From: Matthew Pickup [REDACTED]
Sent: 11 October 2013 09:22
To: Janice Chapman
Cc: Bryan Fry
Subject: RE: BR/212/13 - Changes to window details on the front east elevation, Flint House/The Old Bakery, Bakery Lane, Bognor Regis

Subject: BR/212/13 - Changes to window details on the front east elevation, Flint House/The Old Bakery, Bakery Lane, Bognor Regis

Drawing Number 4834/10.

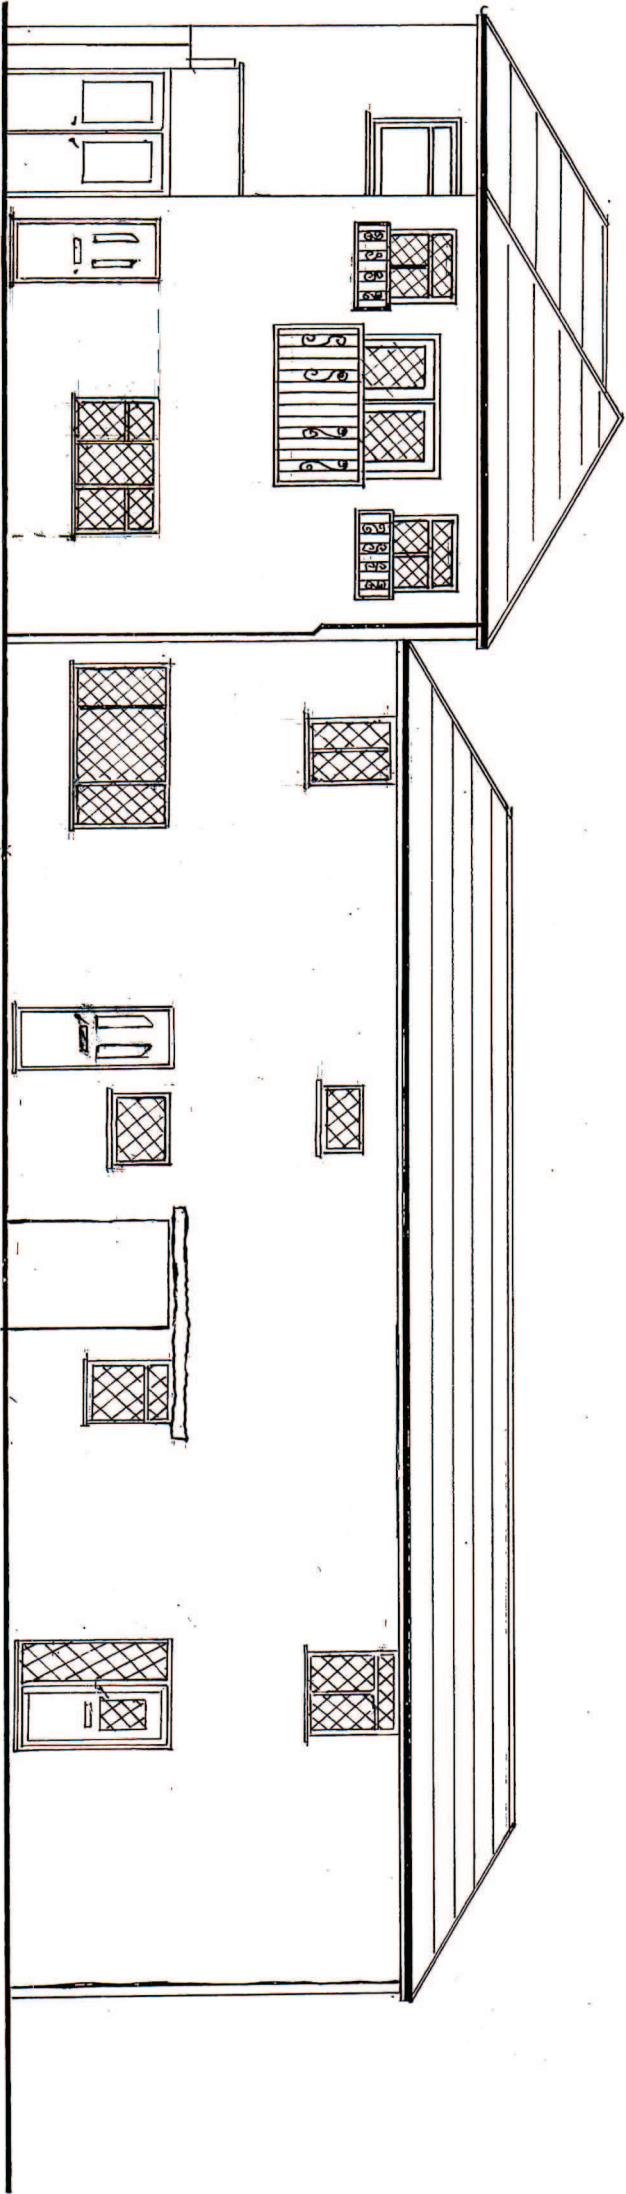
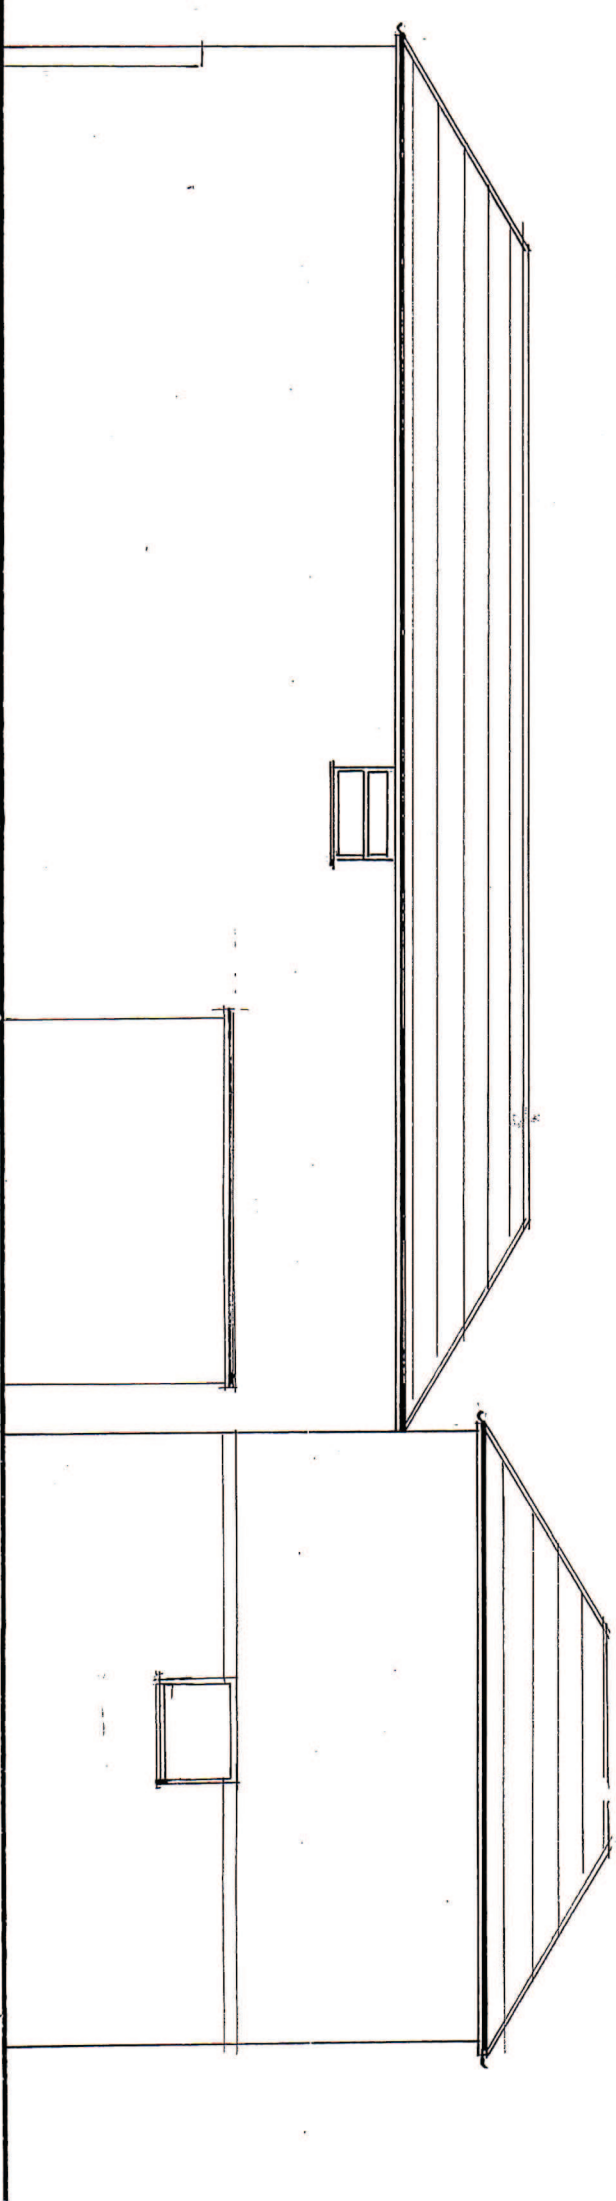
From a site inspection the existing windows on the front elevation are a mixture of white and brown PVCu. The application states that the windows are to be white PVCu with leaded lights. I am of the opinion that brown windows would be more appropriate on this elevation as they would be more in keeping with the brickwork/flintwork.

Would you be happy to amend the application.

My client has now confirmed that he is happy to change the colour of the window frames from white to brown as per your email.
